Project #: 1009082 Application #: 13DRB-70632, 13DRB-70633

Project Name: City of Albuquerque

Subdivision Name: TRACT 1, BLOCK 2, VOLCANO CLIFFS UNIT 26

12DRB-70082 VACATION OF PUBLIC UTILITY EASEMENT
12DRB-70083 VACATION OF PUBLIC RIGHT-OF-WAY

VACATION EXHIBIT

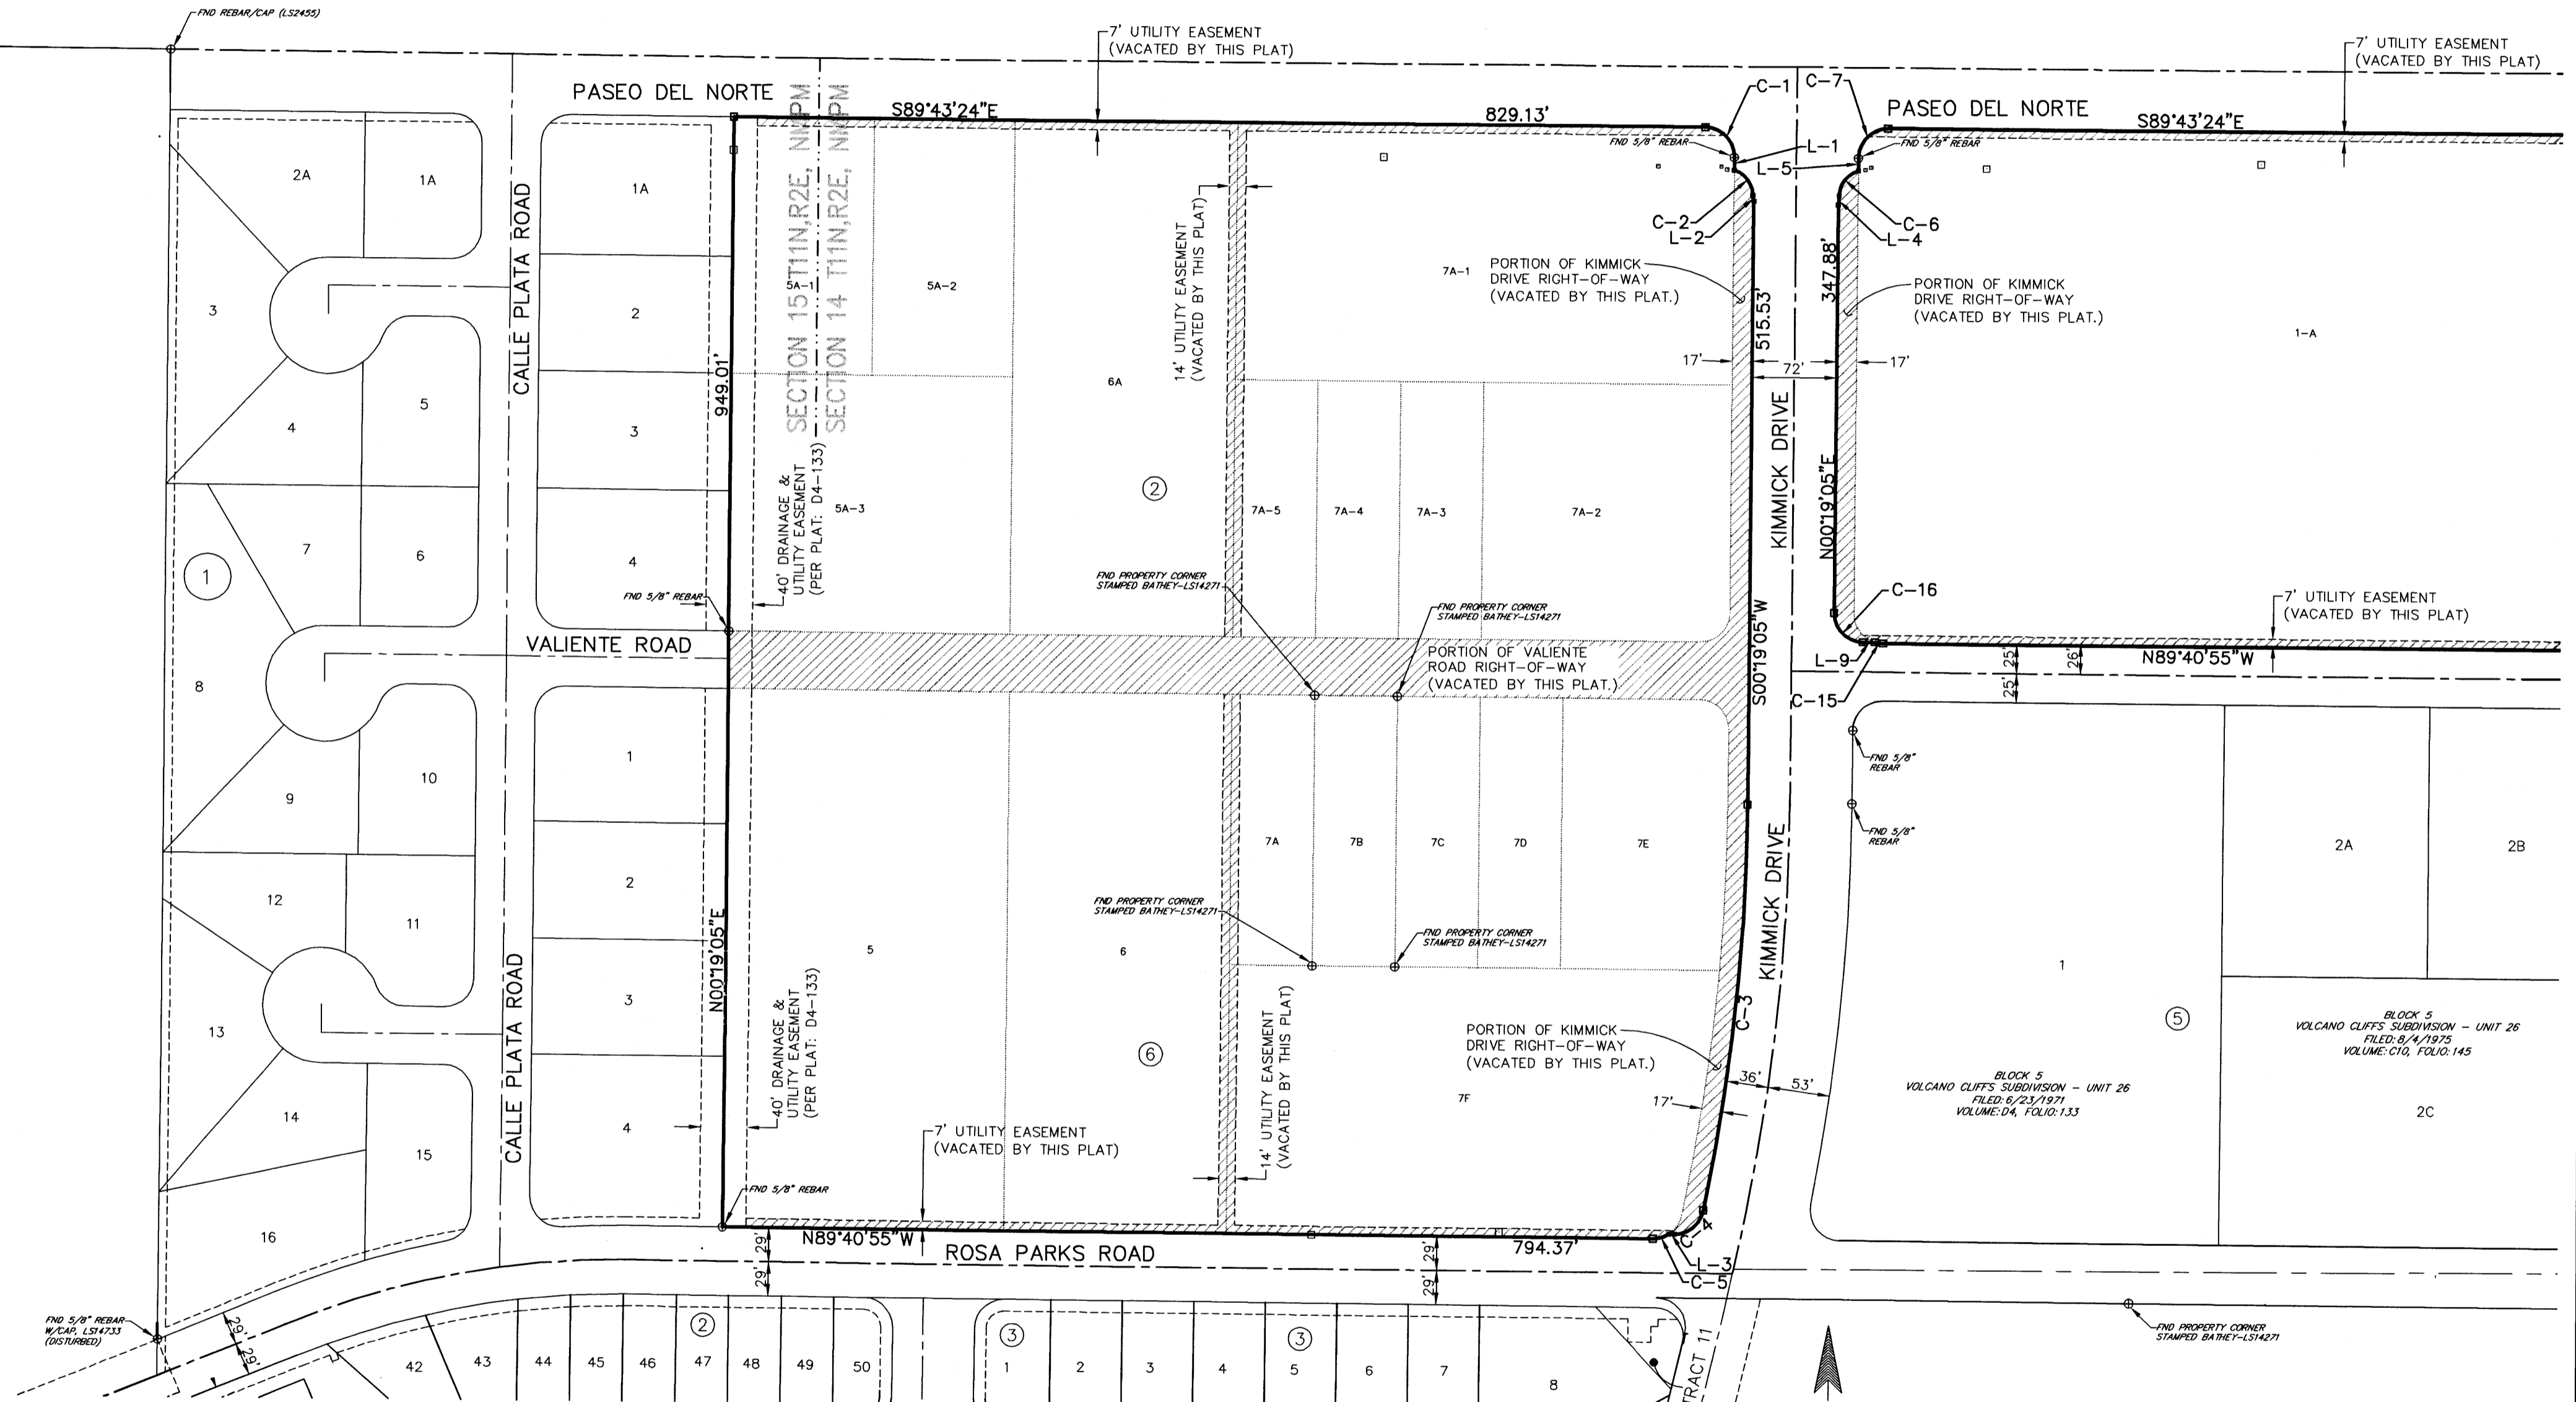
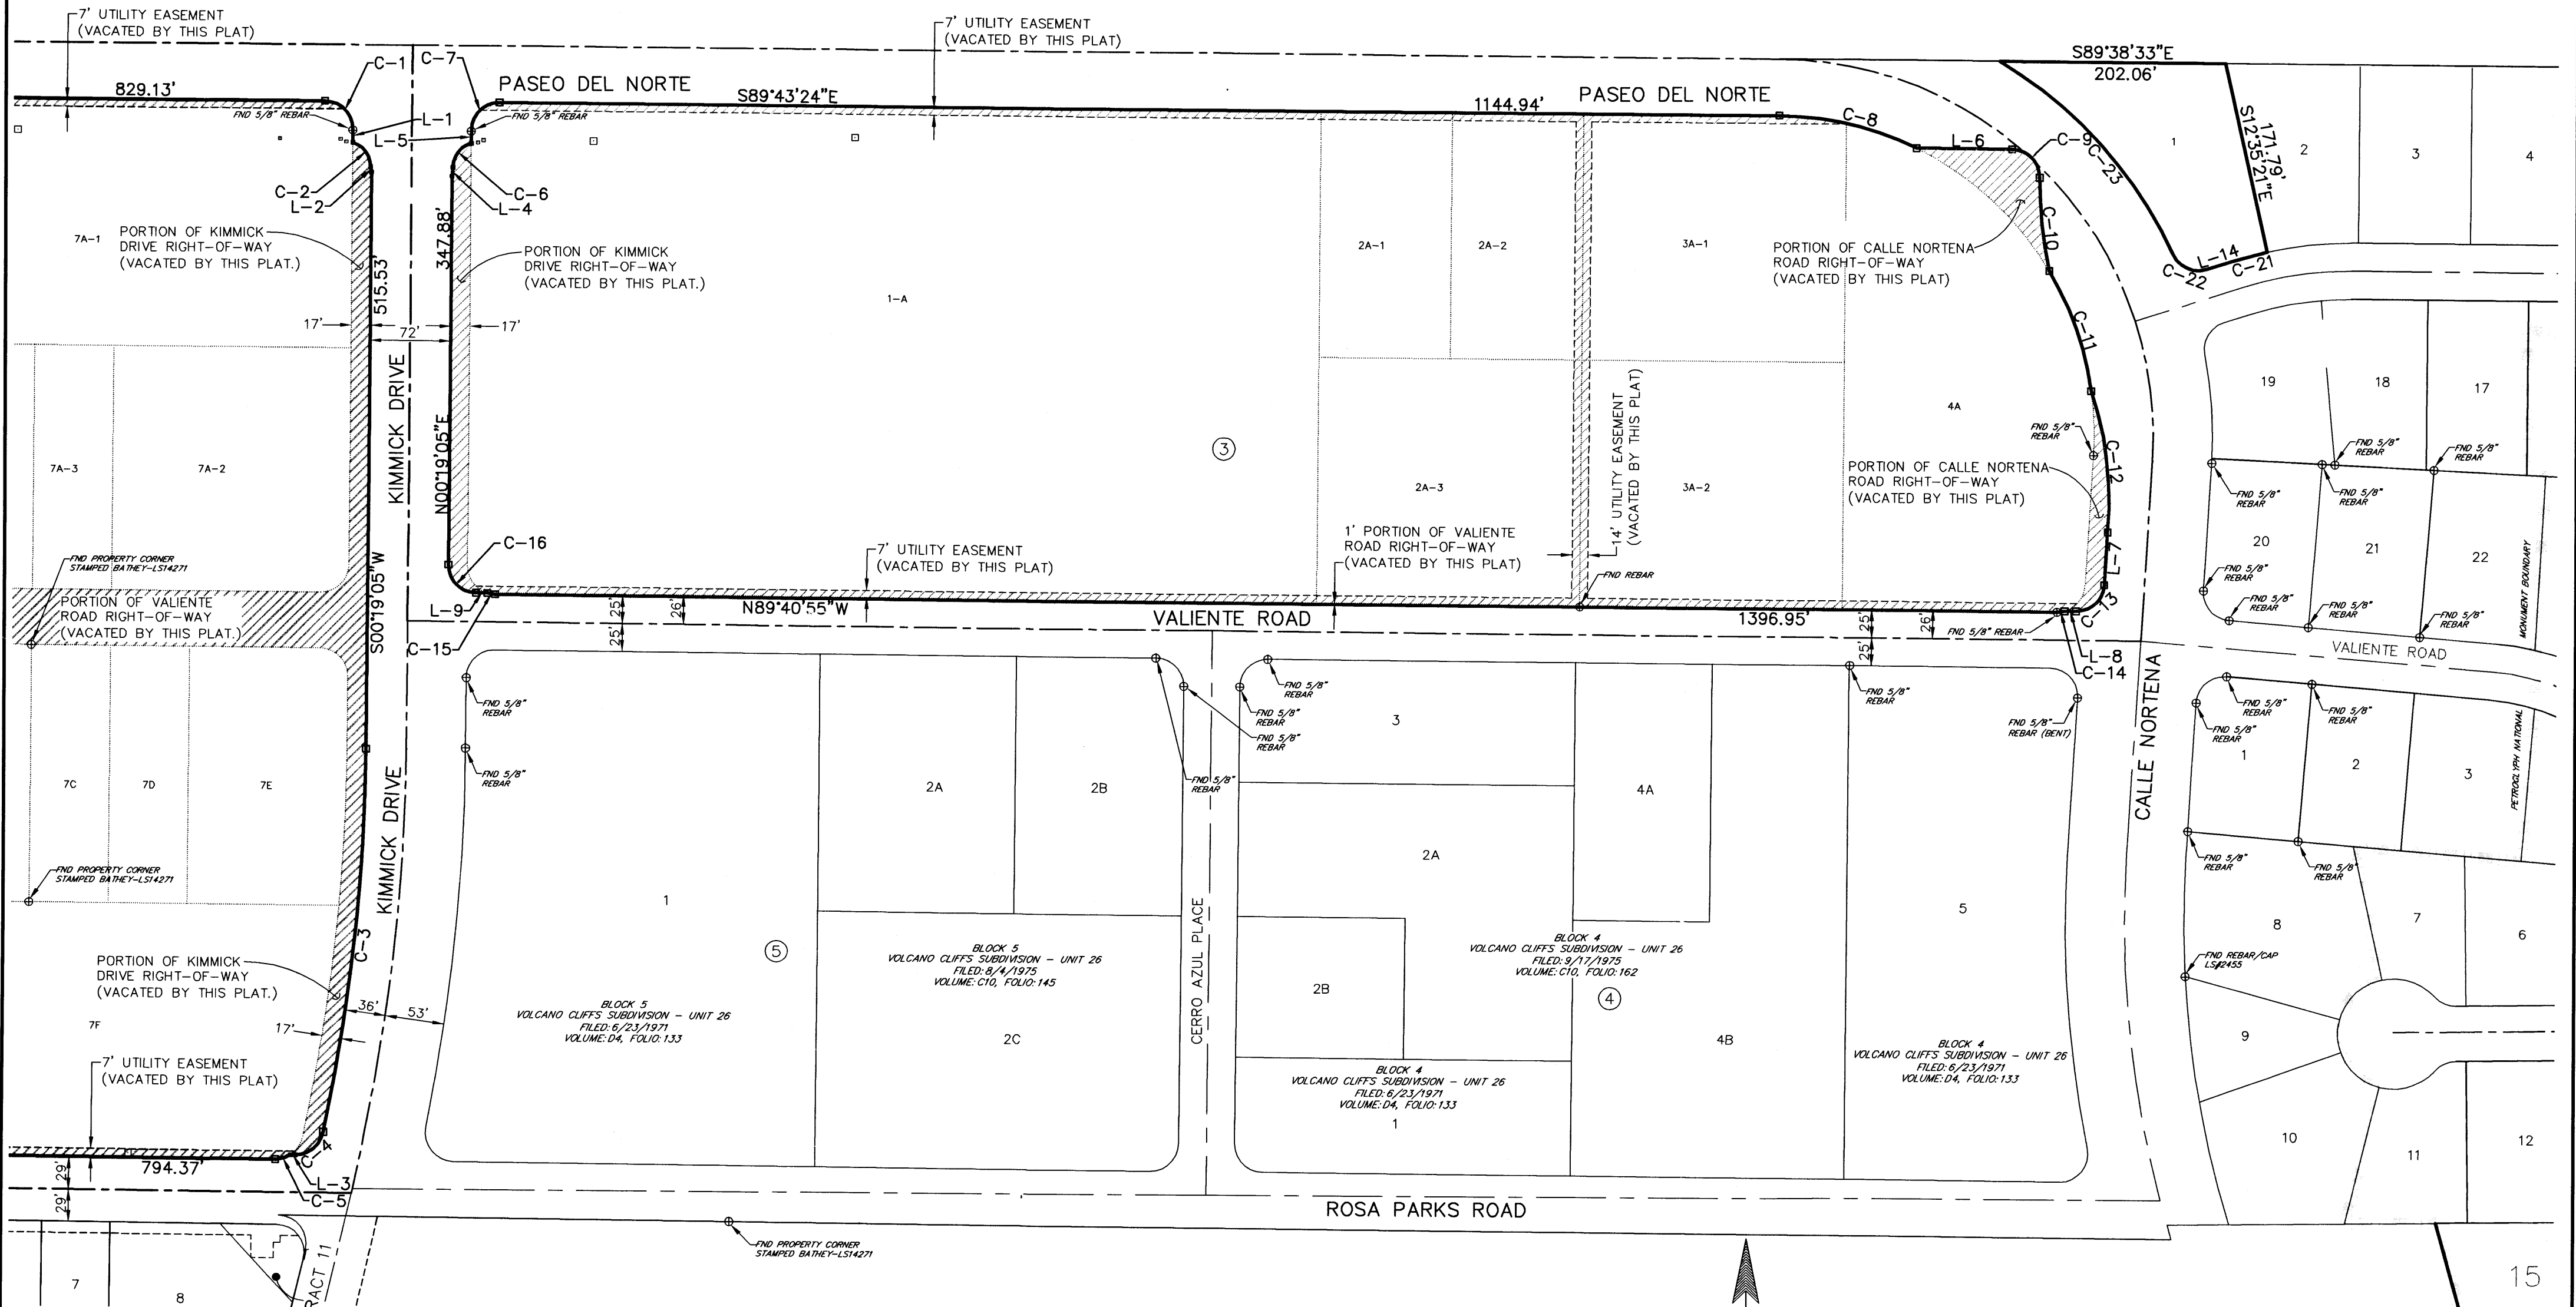
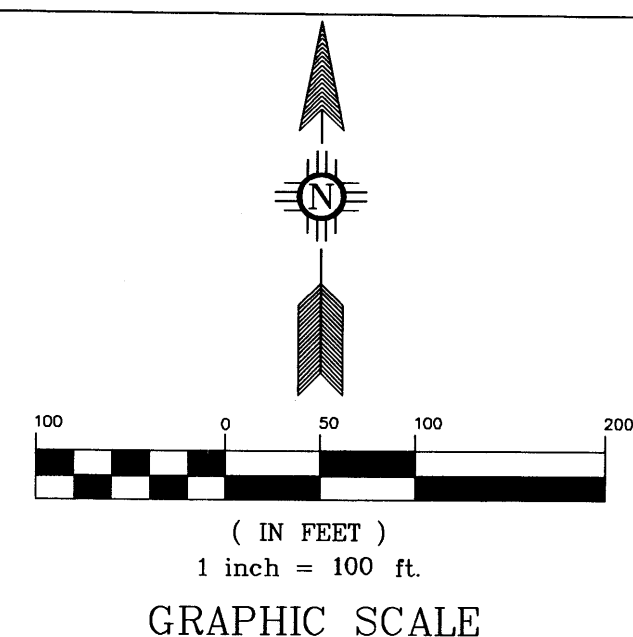
Provide an exhibit showing the location of sidewalk and defining the distance from face of curb to the property line. Right of way dedication may be required.

Provide cross sections for the proposed roadway sections.

What is the roadway classification of Kimmick Drive and Rosa Parks Road? Larger radii may be required at the intersection of Kimmick / Paseo del Norte and Kimmick / Rosa Parks.

Is a traffic signal proposed at Kimmick / Paseo del Norte?

Does Valiente Road meet the criteria for a stub street (maximum number of units is 4 and the maximum length is 150' measured from the centerline of the intersecting street to the end of the stub street)?

Define the full right of way width of Paseo del Norte (156' ultimate).
